MORGAN AND MORECAMBE OFFSHORE WIND FARMS: TRANSMISSION ASSETS

Annex 2.1 to Applicants' Response to Deadline 5 submissions from Statutory Consultees and other organisation: BAE Systems (REP5-159)

Deadline 6
Application Reference: EN020028

Document Reference: S_D6_2.1

**Figure 1.4: Pond creation at Moss Side**

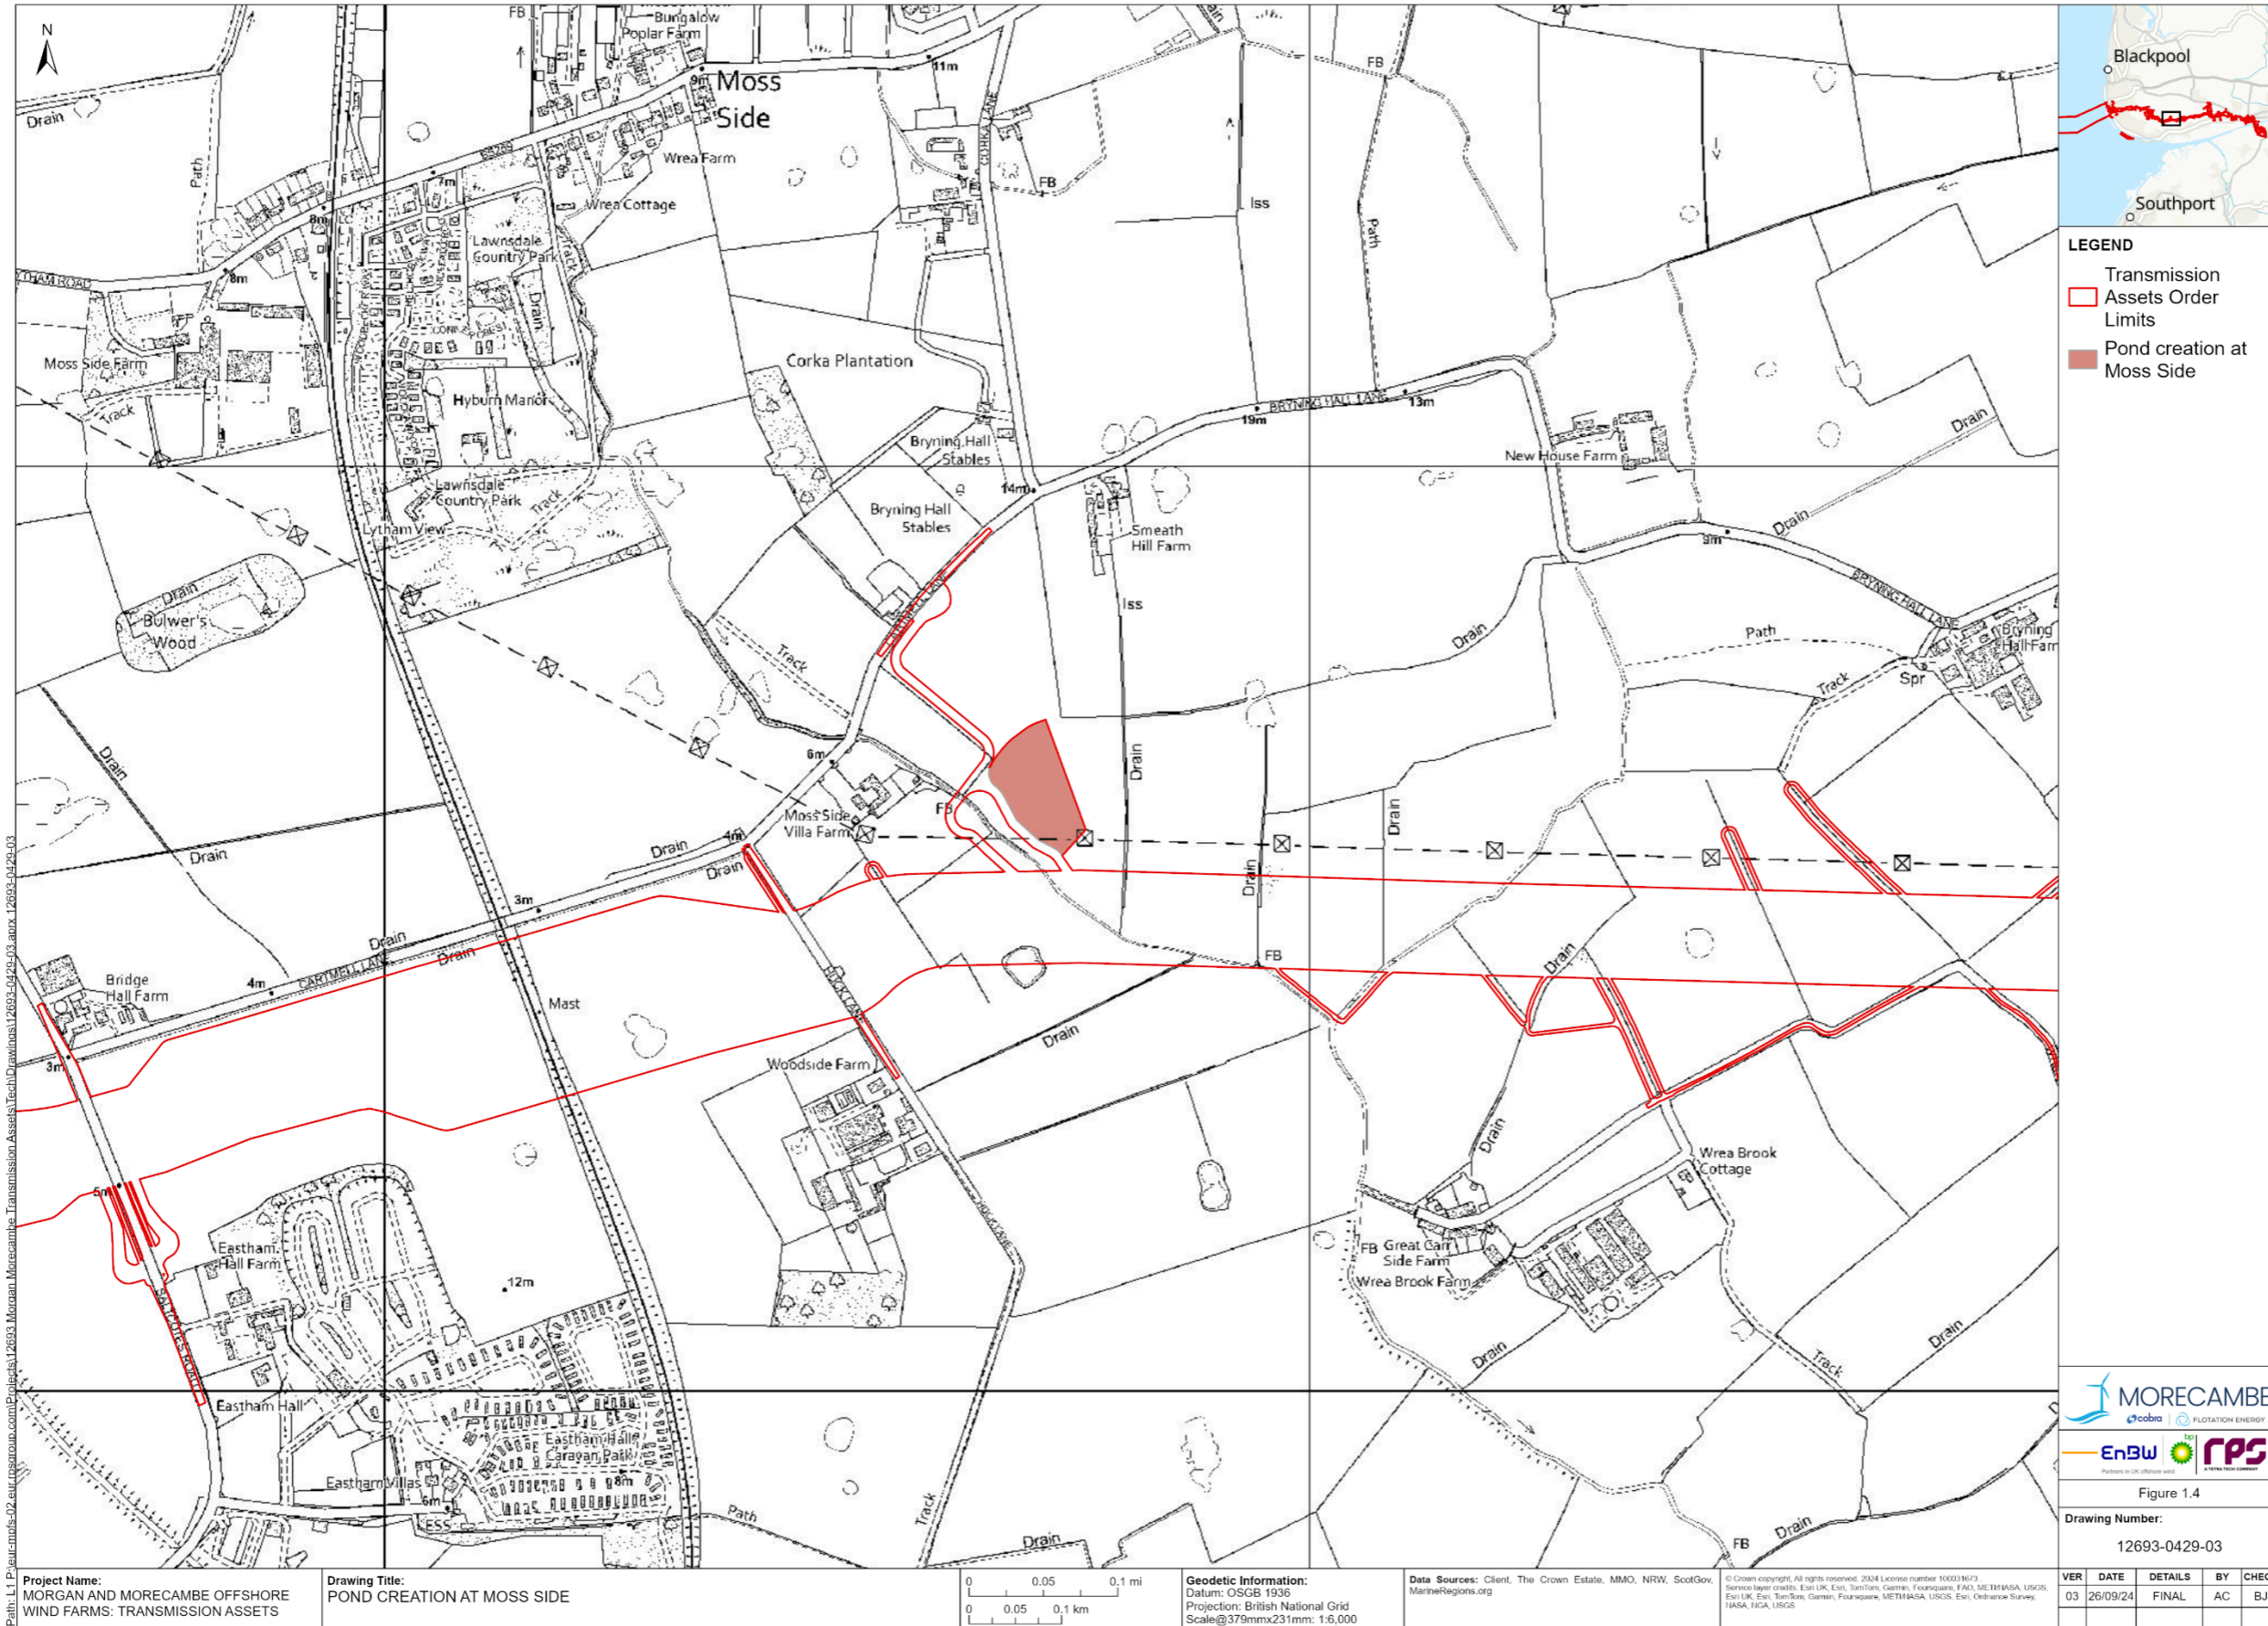
Q2:4.1.8	<p>Mitigation areas</p> <p>In their reply [REP3-056] to Q4.1.6 to ExQ1, the applicants state that “the new pond creation areas at Moss Side and the Morgan Onshore Substation are intended as mitigation for the loss of existing ponds; therefore, there will be no net gain in standing water, but rather a redistribution within the 13 km safeguarding radius of the Warton Aerodrome.” Can BAE respond to this?</p>	<p>BAE Systems and DIO have provided initial comments to the Applicants on the high-level design considerations for the environmental/ecological and biodiversity benefit areas, including the proposed ponds at Moss Side and the Morgan onshore substation site, with the aim of reducing attractant risk.</p> <p>Regarding the ponds in particular, it is considered that a series of smaller ponds, rather than a single large body of water, would be less attractive to birds, but provide a suitable habitat for other forms of wildlife. Furthermore, the creation of steep banks, tall planting on</p>	<p>The Applicants can commit to ensuring that the design and ongoing management of any pond creation will be such to ensure they are at low risk of attracting birds to an unacceptable level. The Applicants have committed to consulting both the BAE Systems and DIO on the final design of the ponds, so they are made as ‘unattractive’ to aviation interests as possible. This commitment is secured in the agreed wording of dDCO Requirement 27, which was updated and submitted at Deadline 6 (C1/F09).</p>
